From: Karen Walter <KWalter@muckleshoot.nsn.us>
Sent: Tuesday, May 14, 2019 11:41 AM
To: Nicole Gaudette
Subject: Yang Single Family Residence, Critical Area Determination/ Buffer averaging, CAO19-006, Notice of Application

We have reviewed the proposed Yang Single Family Residence Critical Area Determination/Buffer averaging proposal referenced above. We have some questions and initial comments about this project:

**PROJECT MANAGER:** RK  
**DESIGNED:** RK/KMB/GM  
**DRAFTED:** GM  
**CHECKED:** RK/KMB  
**JOB NUMBER:** 180605  
**SHEET NUMBER:** W1 OF 7

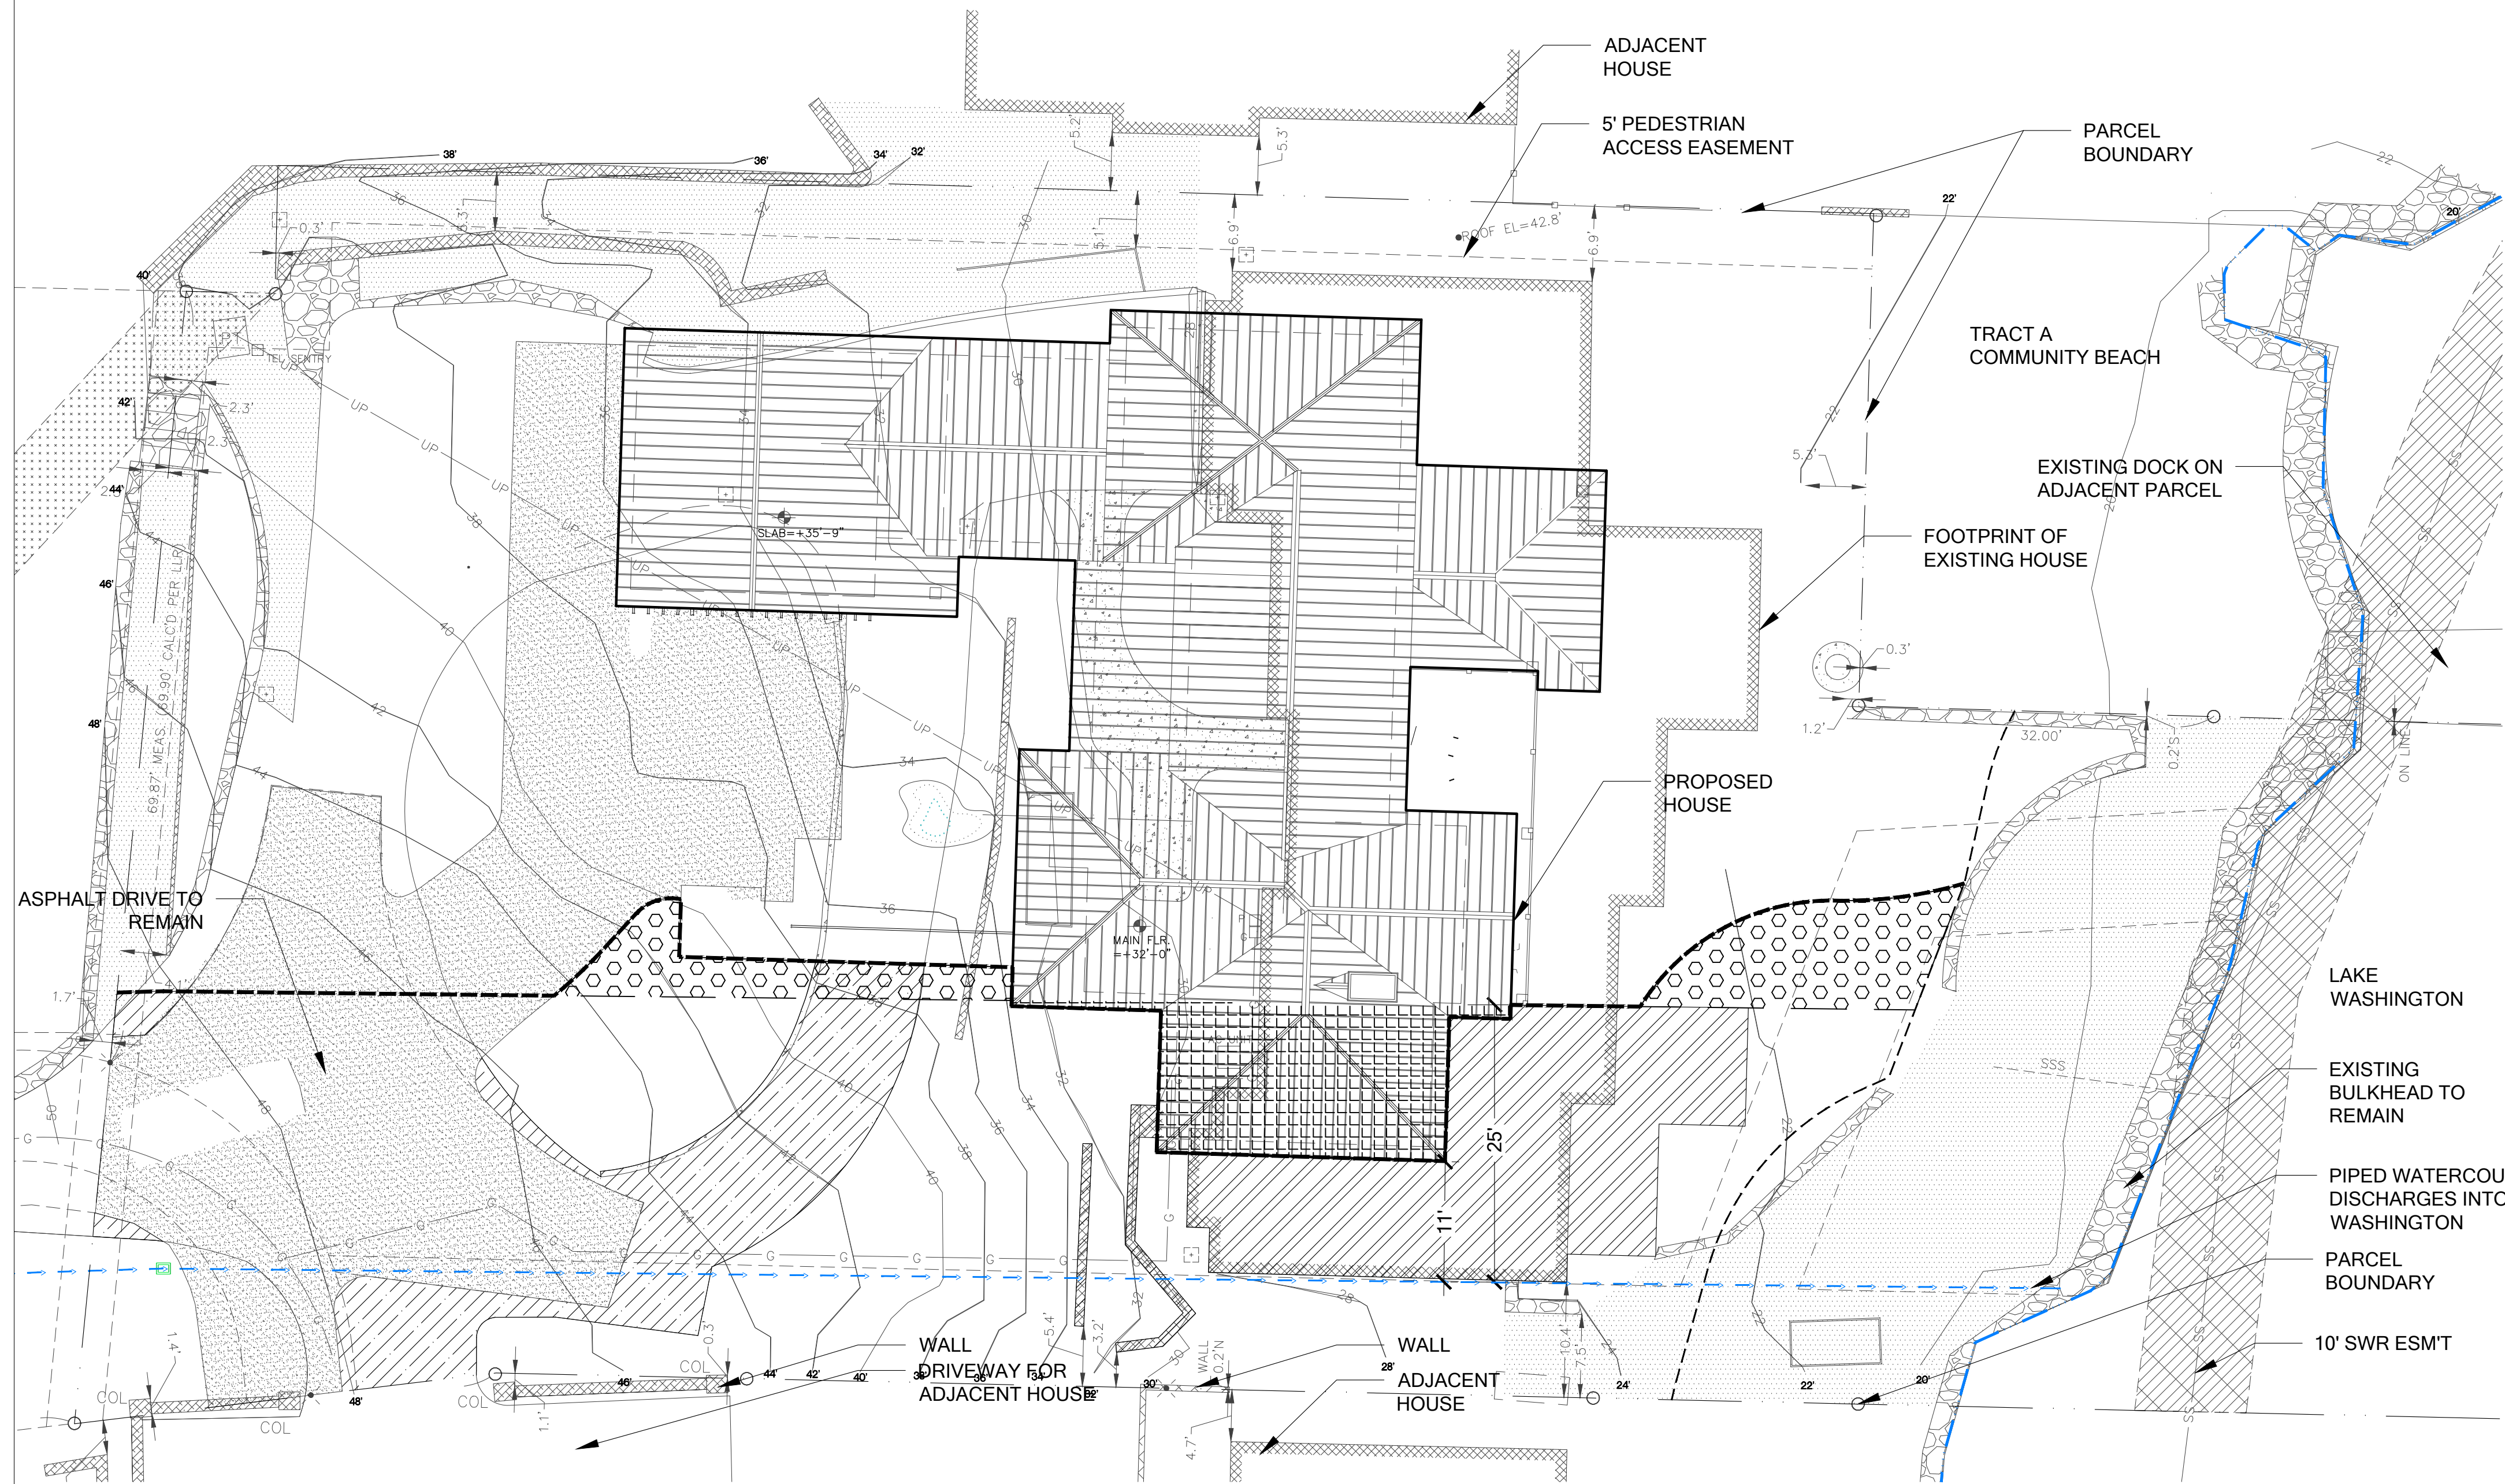
1. As noted in the Critical Areas Report for the project, there is an existing watercourse (stream) onsite that is currently piped throughout its length on this property until it discharges into Lake Washington. With the project site being fully redeveloped, this is the opportunity to daylight this stream. Please explain why this project is not daylighting this stream as part of this project, particularly given the new home's location farther away from this piped watercourse. As part of this response, please note the approximately date as to when this stream was piped and the condition of this pipe.

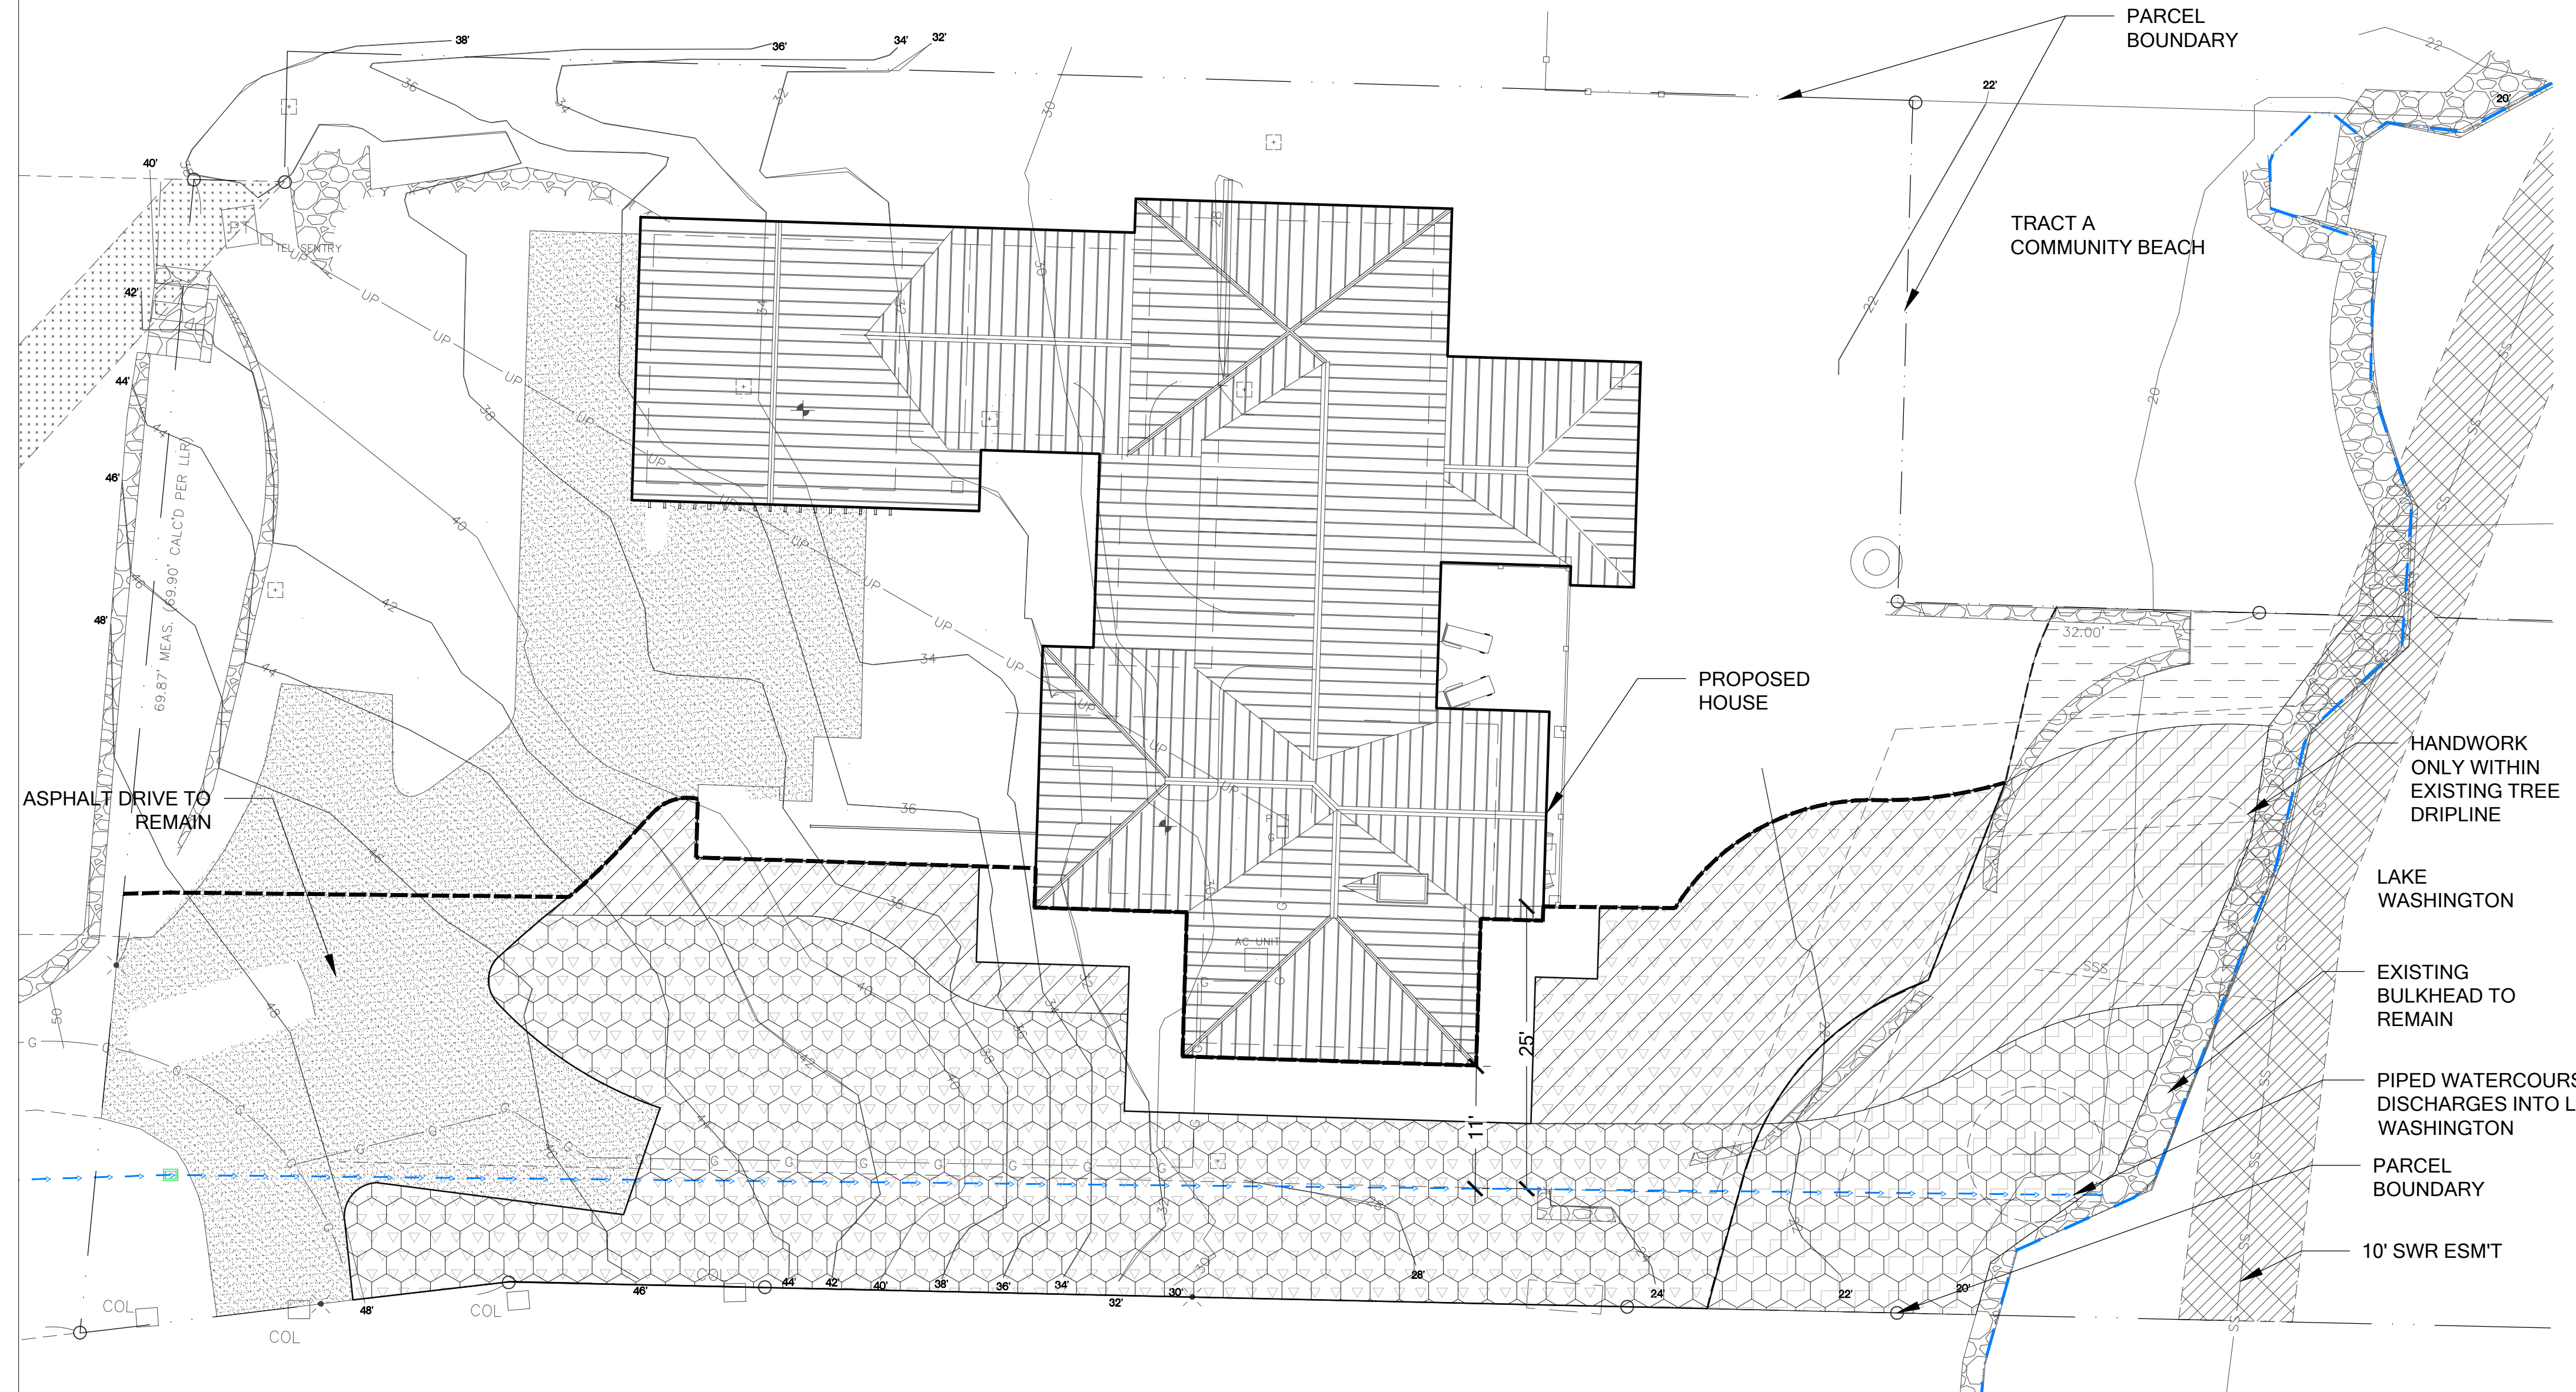
2. The plans note a few existing trees (unidentified pine species) will be removed from areas adjacent to the piped stream and Lake Washington. The proposed critical areas planting plan shows no new trees along the piped stream and planted areas Lake Washington. There should be trees planted to replace those removed or at least some native willows that will provide more habitat functions along the nearshore of Lake Washington than those shrub species proposed.
